PLANNING CONSULTATION RESPONSE

Application No	2025/0153
Proposal	2025 0153 Demolition of existing dwelling (retro) and erection of 1no. detached dwelling with integral garages Hirst Cottage Billingley Updated Plans 040925
Address	Hirst Cottage Chapel Lane Billingley
Date of Consultation Reply	05.12.25
Consultee	Tony Wiles Senior Conservation Officer

FRONT ELEVATION (N)
SCALE 1:100

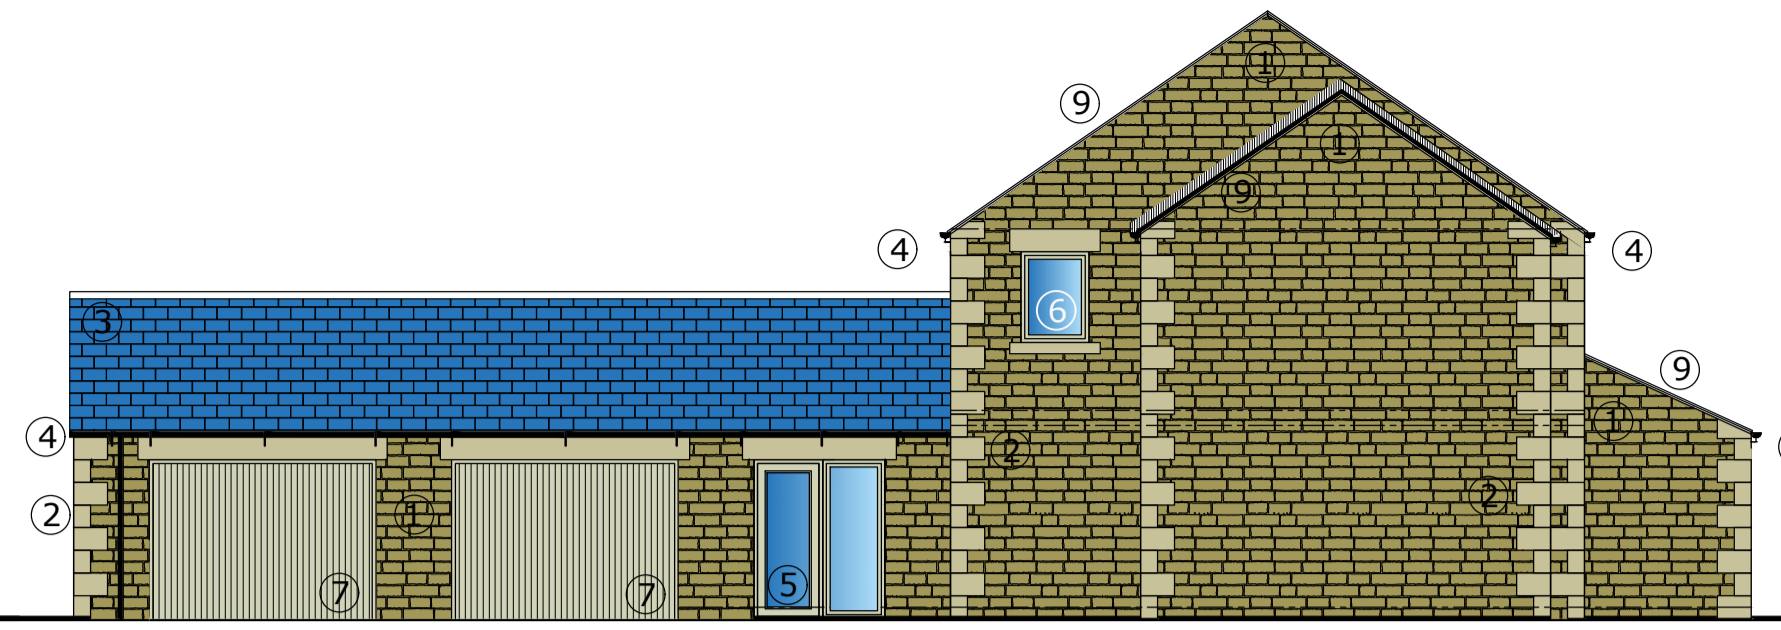
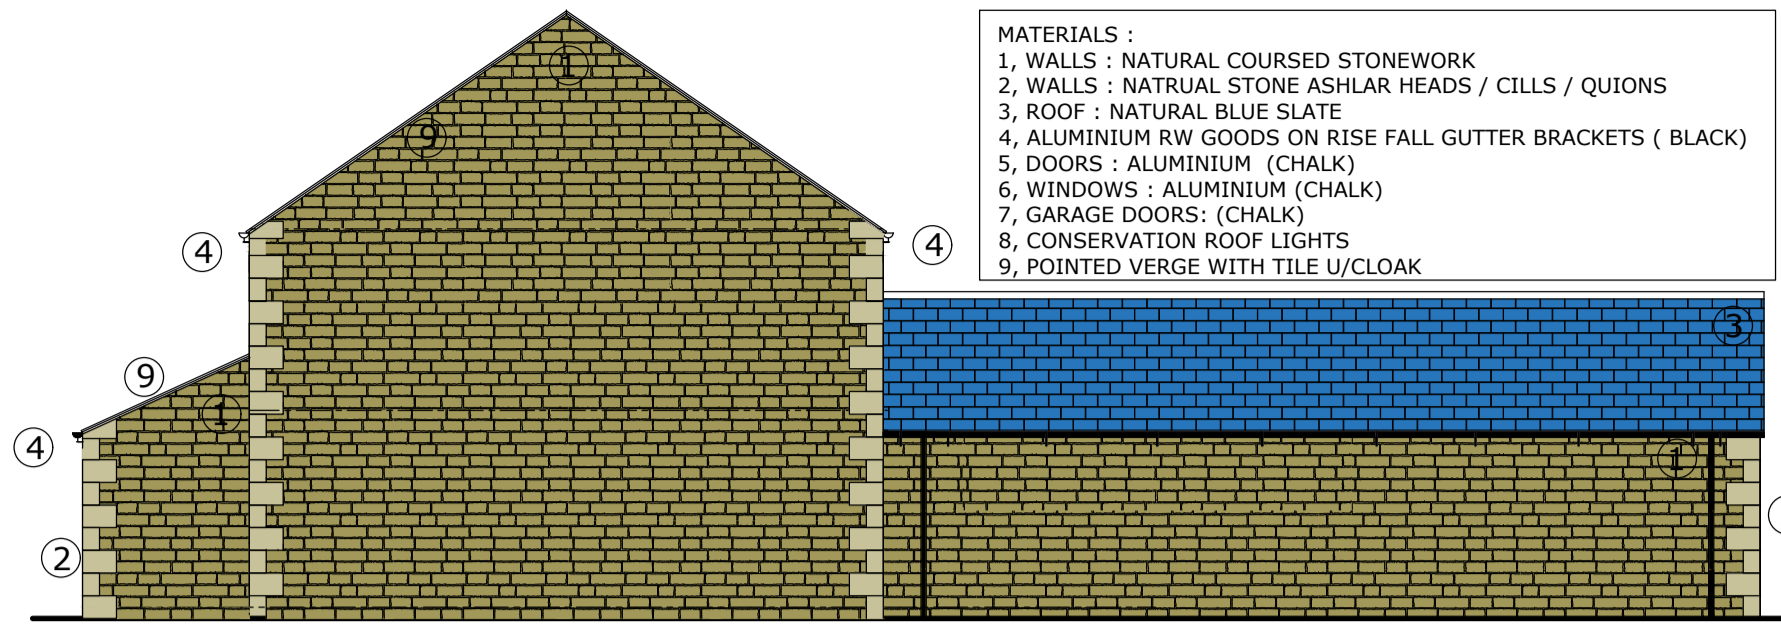
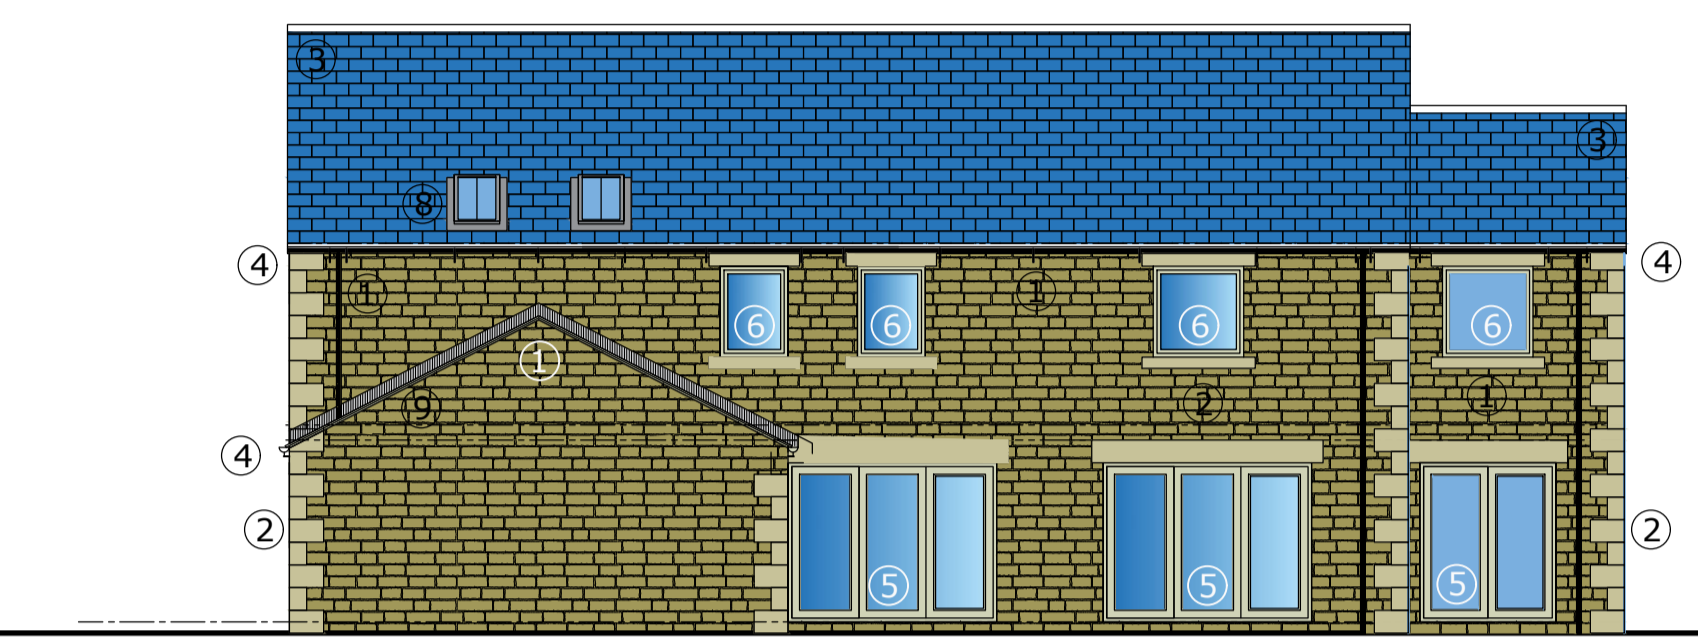
- *Front gable omitted, restoring the vernacular appearance, form and scale of the front elevation.*
- *The garage projection reduced back to a double garage, with the room above and dormer windows omitted.*
- *Appropriate detailing added to the fenestration (quoins, windows surrounds etc.).*
- *Position and footprint very similar to the approved extension scheme.*

The loss of the original cottage was obviously harmful. However, that aside the newest plans are in my view sympathetic to the character of the conservation area and in general reflect the scale and appearance of the originally approved plans. The scale, massing, materials and architectural detailing are less grandiose than previous iterations and more akin to the local vernacular. The design does include a full height (cart type) glazed opening that reflects that of a barn conversion. It is therefore more agricultural in style and less domestic as per the original appearance of the cottage. There are however plenty of examples of such a feature elsewhere in the conservation area and on balance I feel it would be incorrect to insist this is out of keeping. Overall, the use of coursed stone, and slate to the roof, aligned with the more restrained design show a design that I feel will adequately preserve and enhance the character of the conservation area. As such, I feel this new proposal accords with S.72(1), HE1, and NPPF 219.
